Medworth Energy from Waste Combined Heat and Power Facility

PINS ref. EN010110
Document Reference: Vol 9.20
Revision: 2.0
Deadline 2
March 2023

Schedule of Changes (Deadline 2)

**Figure 10.1i**  
**New Bridge Lane access design**

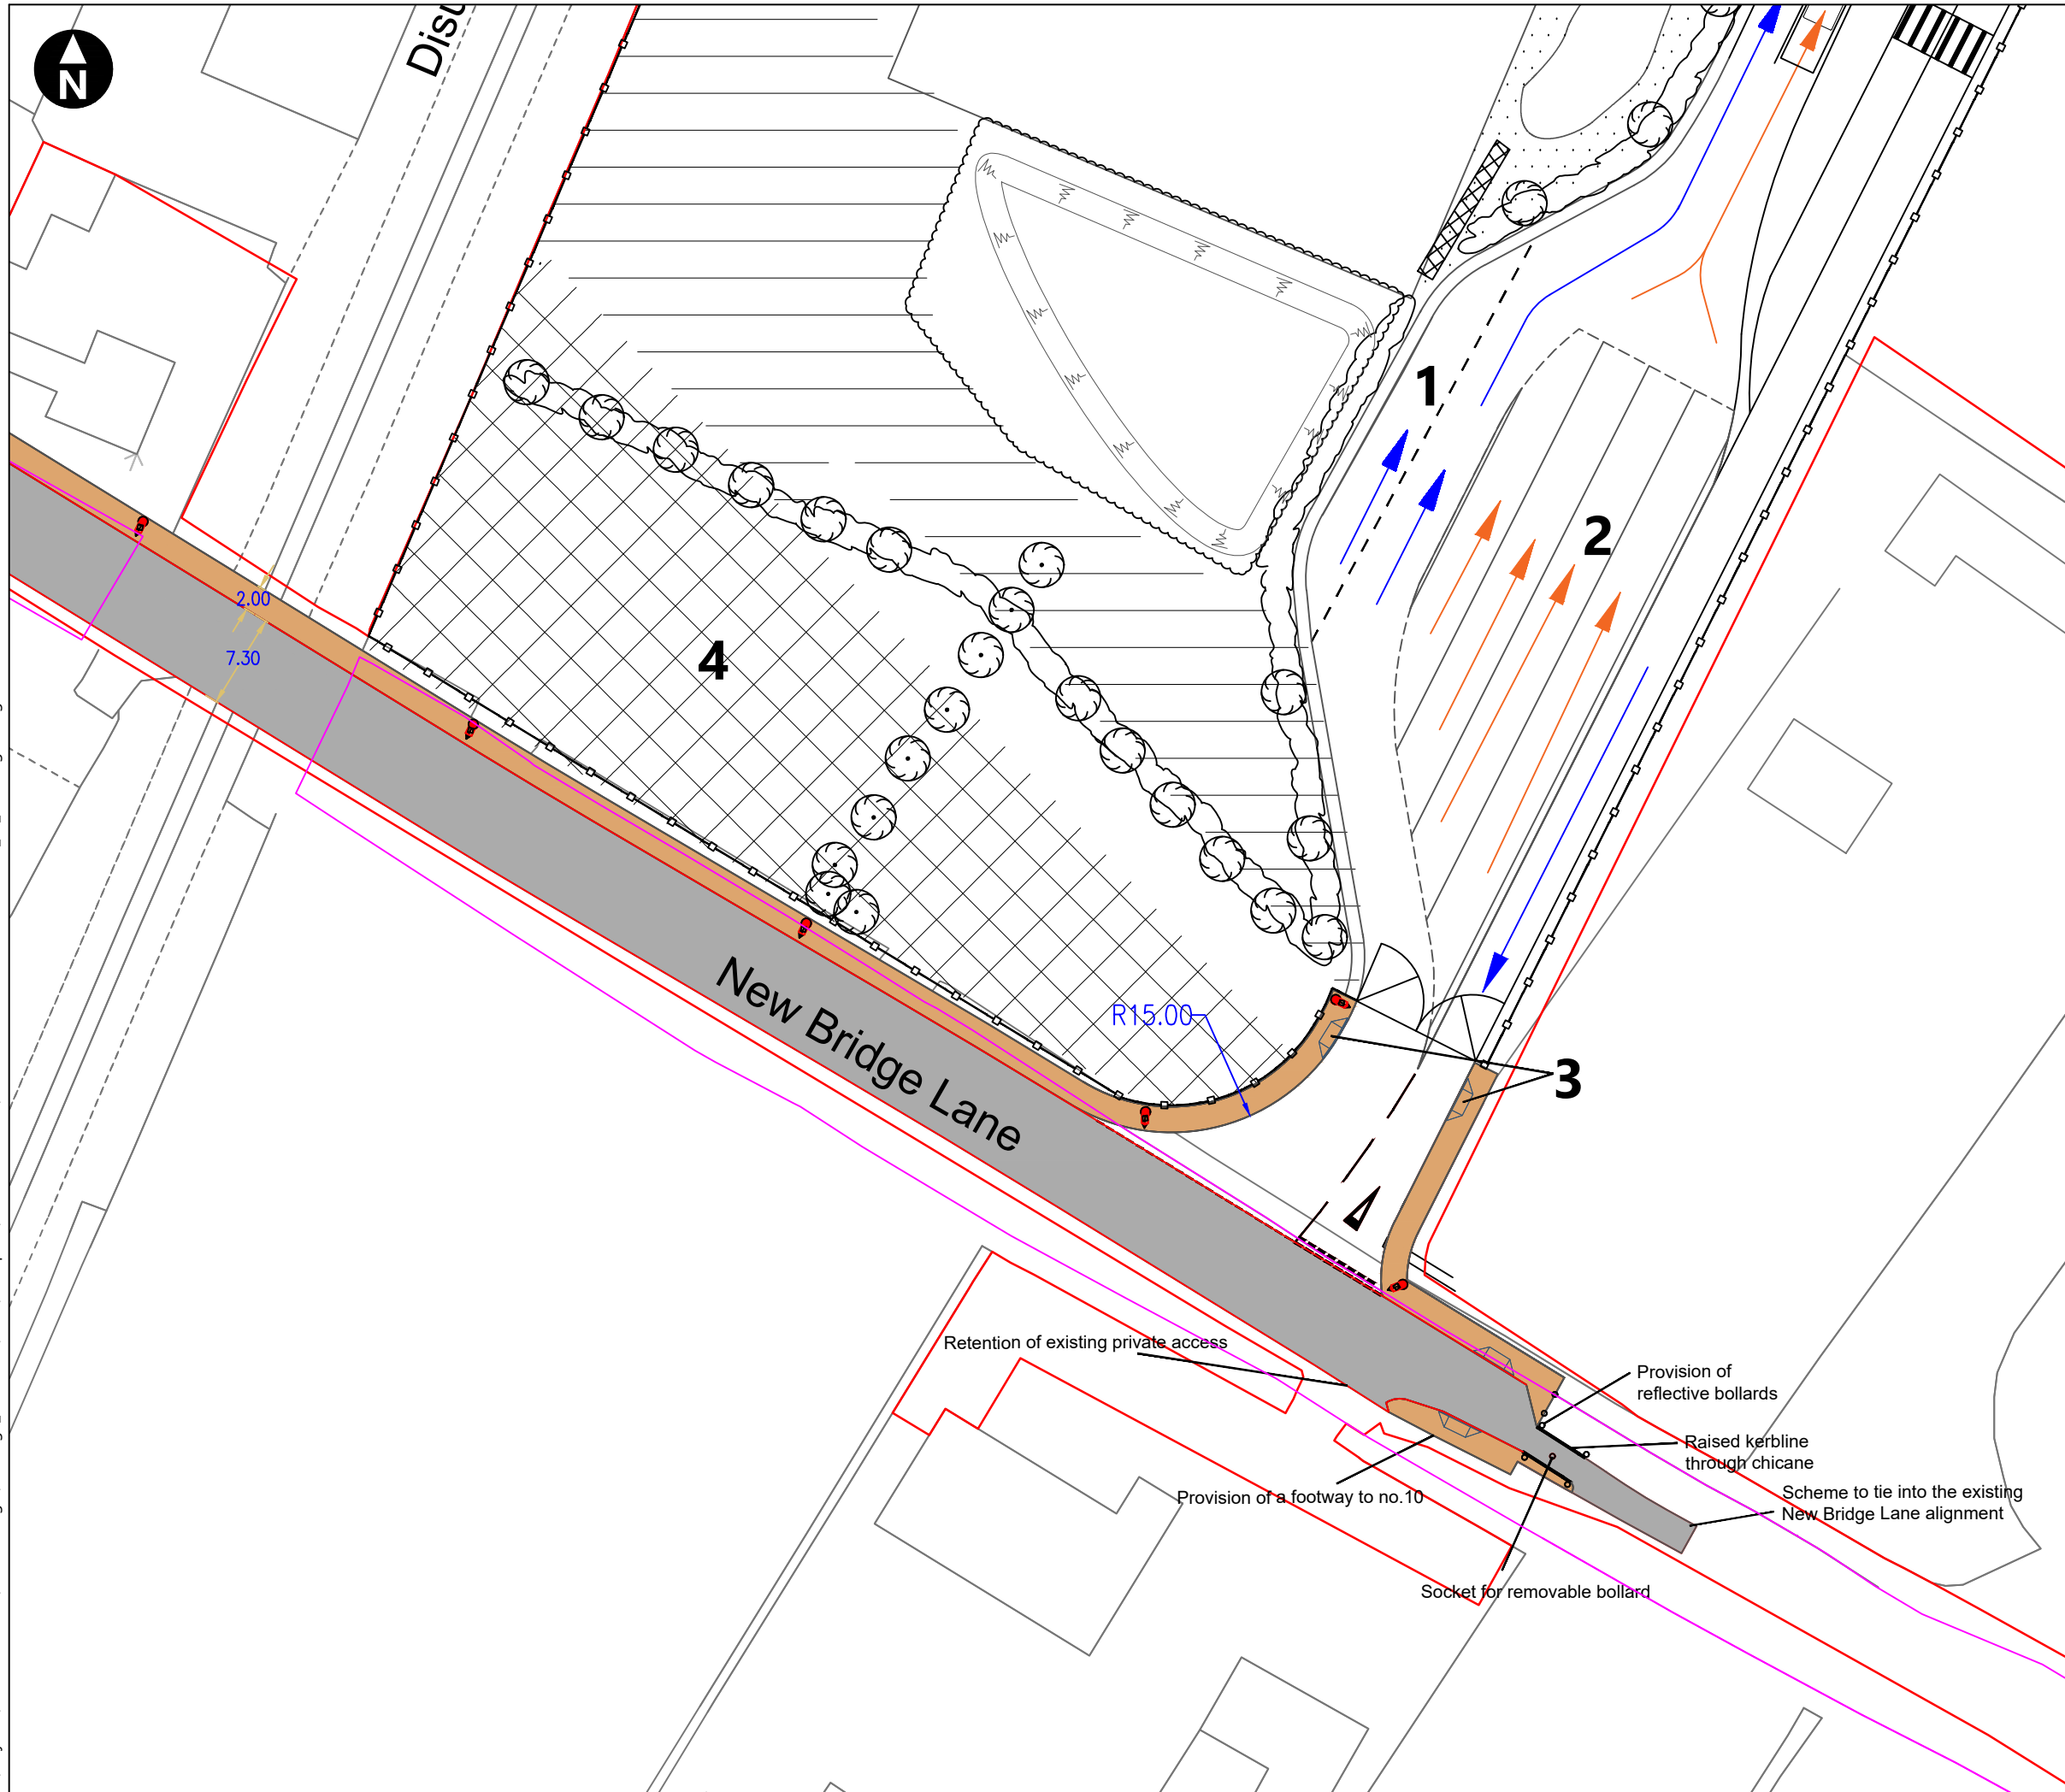
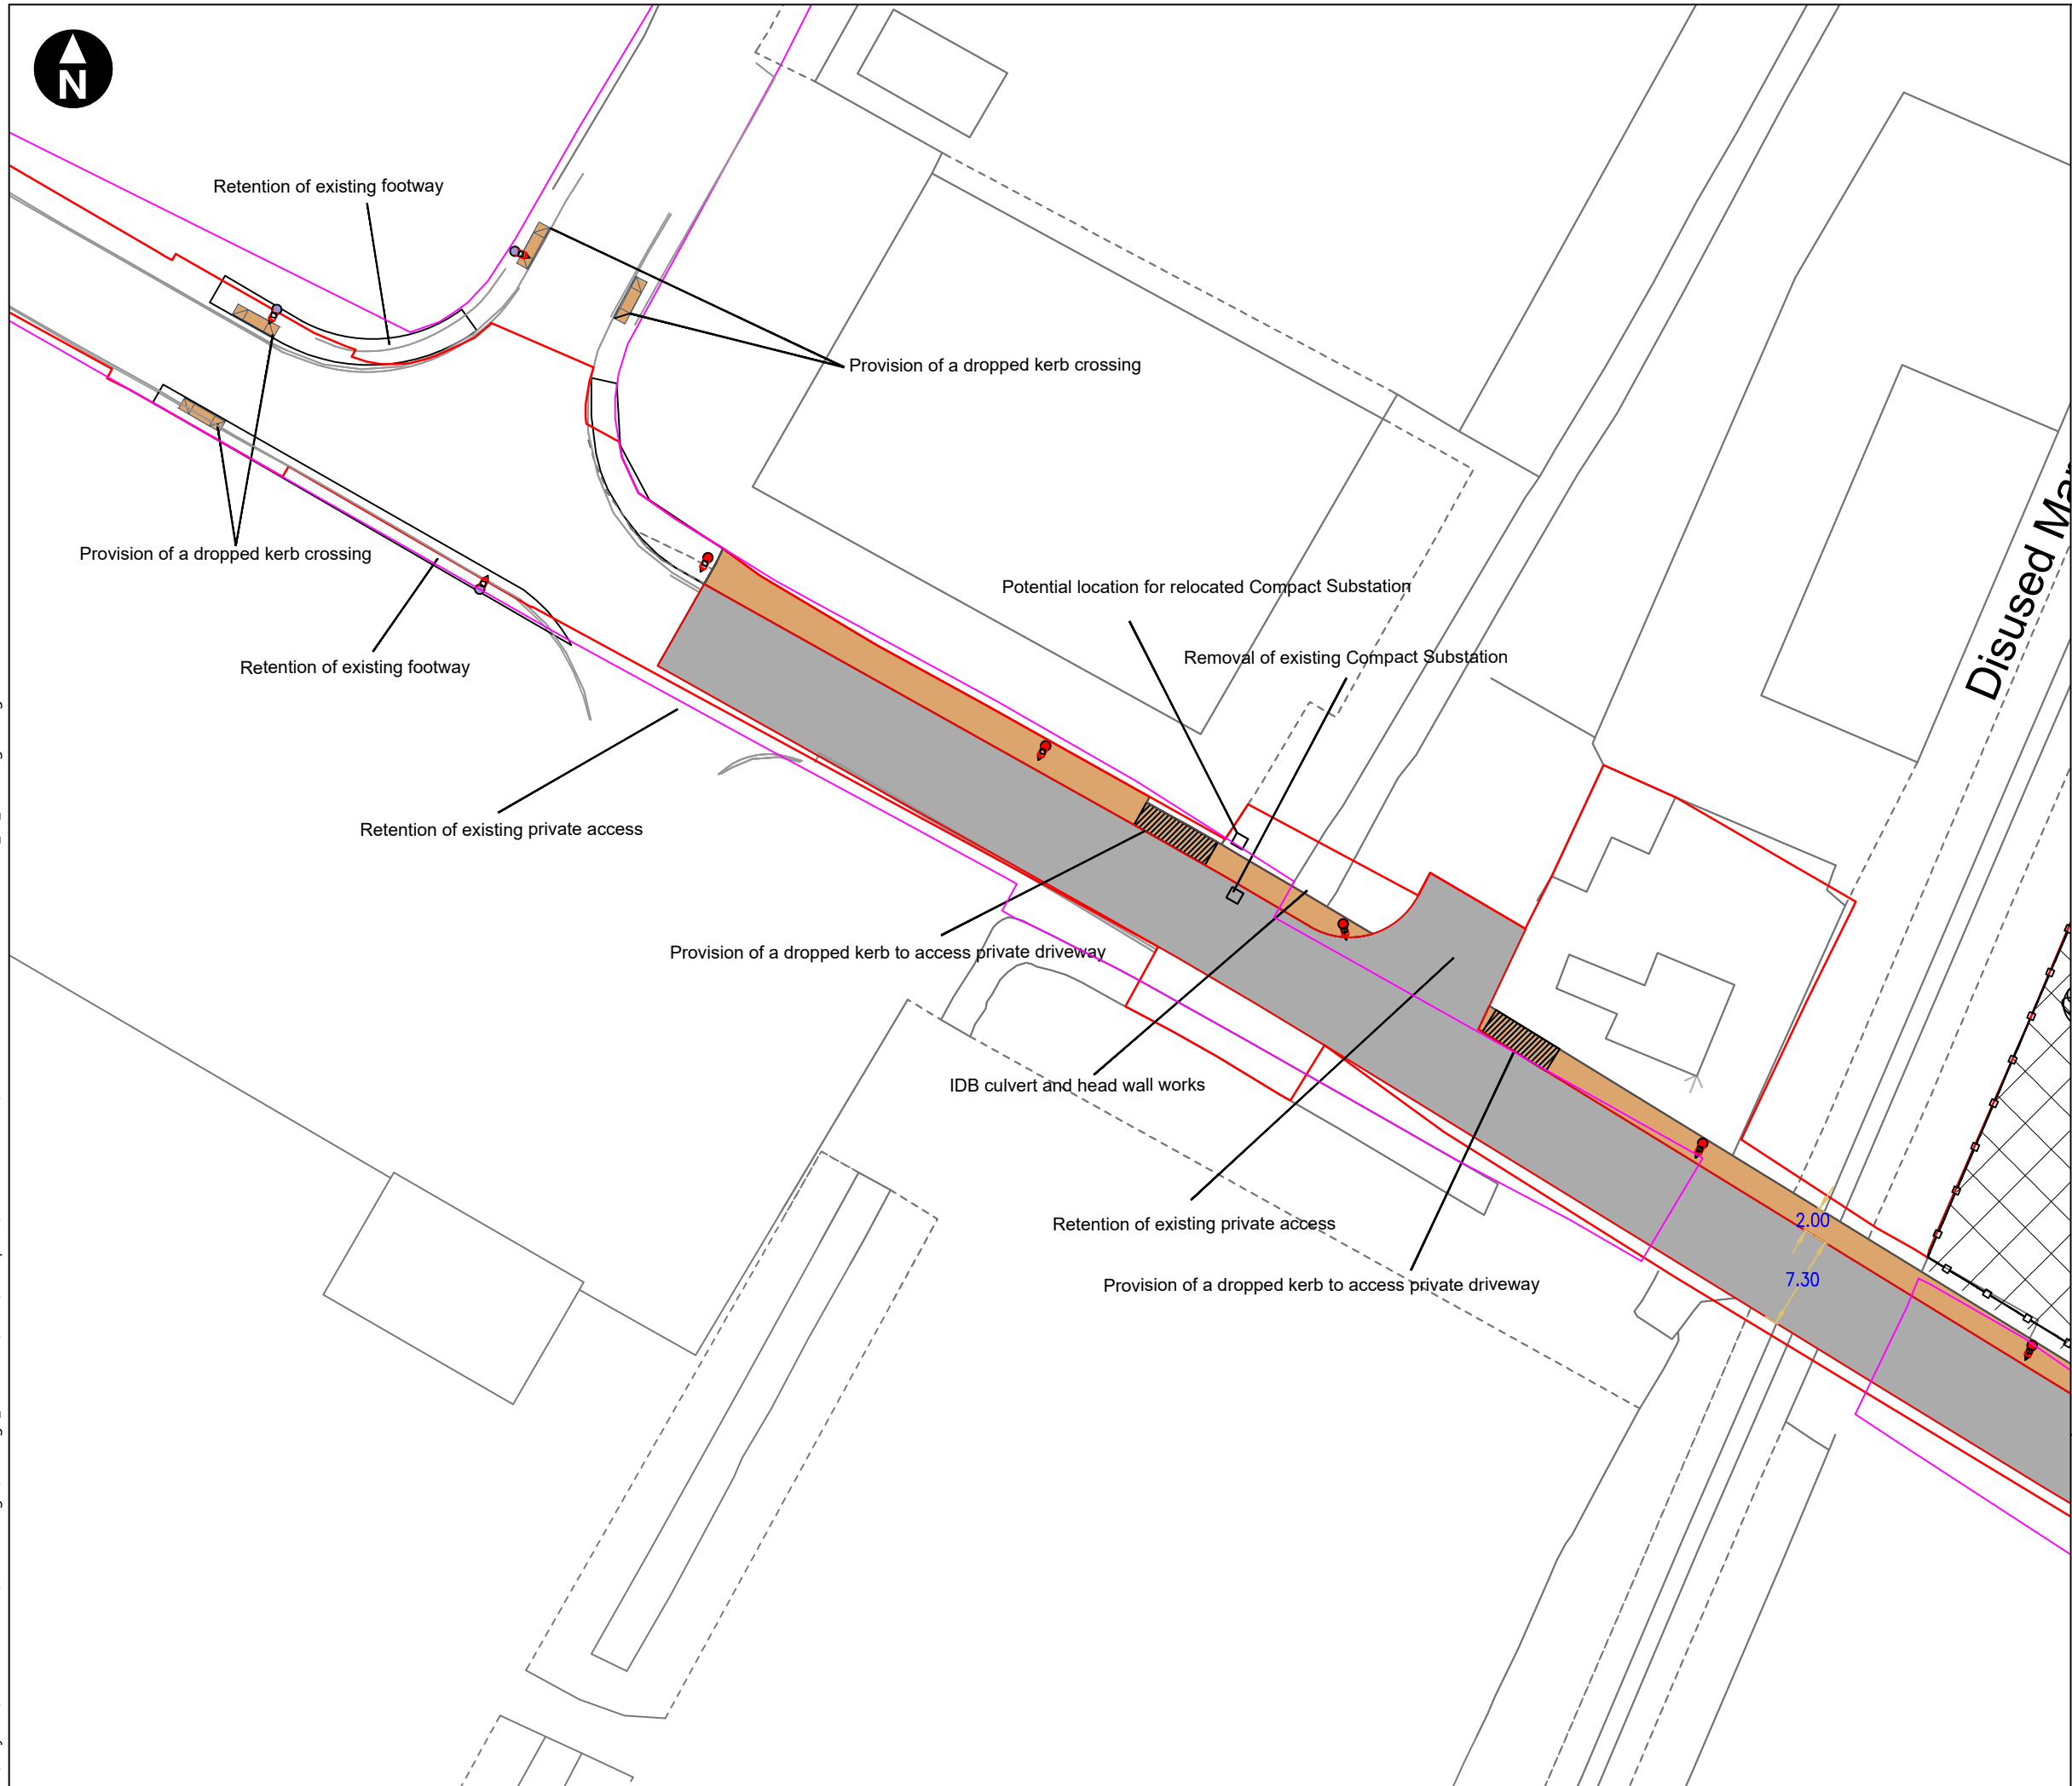
Document Updated	Change	Reason for change	Deadline submitted	Relevant Document version
Traffic Management Plan (CTMP) [APP-072]				
Volume 6.4 ES Chapter 6 Traffic and Transport Appendix 6A Outline (CTMP) [APP-072]	Paragraph 4.6.2 – 4.6.3, Section 4.9 – text added to outline restrictions on construction traffic movements.	FDC and CCC Joint Relevant Representation [RR-002 - RR-003] and ongoing engagement with CCC.	Deadline 1	Rev 2
Volume 6.4 ES Chapter 6 Traffic and Transport Appendix 6A Outline (CTMP) [APP-072]	New Section 4.9 Route restrictions. Confirmation of the restrictions to be applied to the routing of construction traffic and provision of a new figure, Figure 4.3 EfW CHP Facility and TCC construction traffic routes and restrictions.	FDC and CCC Joint Relevant Representation [RR-002 - RR-003] and ongoing engagement with CCC together with comments made at OFH.	Deadline 1	Rev 2
Volume 6.4 ES Chapter 6 Traffic and Transport Appendix 6A Outline (CTMP) [APP-072]	Section 6 title amended to include for works in the highway with a new Section 6.3 to confirm the procedure to be followed with regard to submission of detailed design details to the relevant highway authority and the process for approval.	FDC and CCC Joint Relevant Representation [RR-002 - RR-003] and ongoing engagement with CCC.	Deadline 1	Rev 2

Document Updated	Change	Reason for change	Deadline submitted	Relevant Document version
Volume 6.4 ES Chapter 6 Traffic and Transport Appendix 6A Outline (CTMP) [APP-072]	Paragraph 7.2.3 – maintenance of vehicular access to 10 New Bridge Lane.	In response to [RR-057] .	Deadline 1	Rev 2
Volume 6.4 ES Chapter 6 Traffic and Transport Appendix 6A Outline (CTMP) [APP-072]	Paragraph 7.2.6 – text added to confirm the proposed speed limit reduction along New Bridge Lane	FDC and CCC Joint Relevant Representation [RR-002 - RR-003] and ongoing engagement with CCC.	Deadline 1	Rev 2
Volume 6.4 ES Chapter 6 Traffic and Transport Appendix 6A Outline (CTMP) [APP-072]	Paragraph 7.4.14 – mitigation measures for crossing key points on the highways network.	For the avoidance of doubt.	Deadline 1	Rev 2
Volume 6.4 ES Chapter 6 Traffic and Transport Appendix 6A Outline (CTMP) [APP-072]	Paragraphs 7.4.29-7.4.3 to provide a commitment to advanced notification to businesses ahead of temporary works affecting the highway.	In response to matters raised at the OFH1 and 2.	Deadline 1	Rev 2

Document Updated	Change	Reason for change	Deadline submitted	Relevant Document version
Volume 6.4 ES Chapter 6 Traffic and Transport Appendix 6A Outline (CTMP) [APP-072]	Paragraph 7.4.33 – text inserted to confirm site familiarisation with emergency services would take place.	EEAST relevant representation [RR-013] and the subsequent discussions held on 14 December 2022.	Deadline 1	Rev 2
Volume 6.4 ES Chapter 6 Traffic and Transport Appendix 6A Outline (CTMP) [APP-072]	Paragraph 7.4.33 – text inserted to confirm local liaison group will be set up.	EEAST relevant representation [RR-013] and the subsequent discussions held on 14 December 2022.	Deadline 1	Rev 2
Volume 6.4 ES Chapter 6 Traffic and Transport Appendix 6A Outline (CTMP) [APP-072]	Paragraph 8.2.1 – monitoring requirements confirmed.	For clarity and with reference to commitments made earlier in the document.	Deadline 1	Rev 2
Volume 6.4 ES Chapter 6 Traffic and Transport Appendix 6A Outline (CTMP) [APP-072]	Section 10 added – to include reference to the revised Access Improvement drawings. New drawings included as Figures 10.1 and 10.2 to show the additional street lighting and tactile paving along New Bridge Lane, signalisation of the Cromwell Road/ New Bridge	FDC and CCC Joint Relevant Representation [RR-002 - RR-003] .	Deadline 1	Rev 2
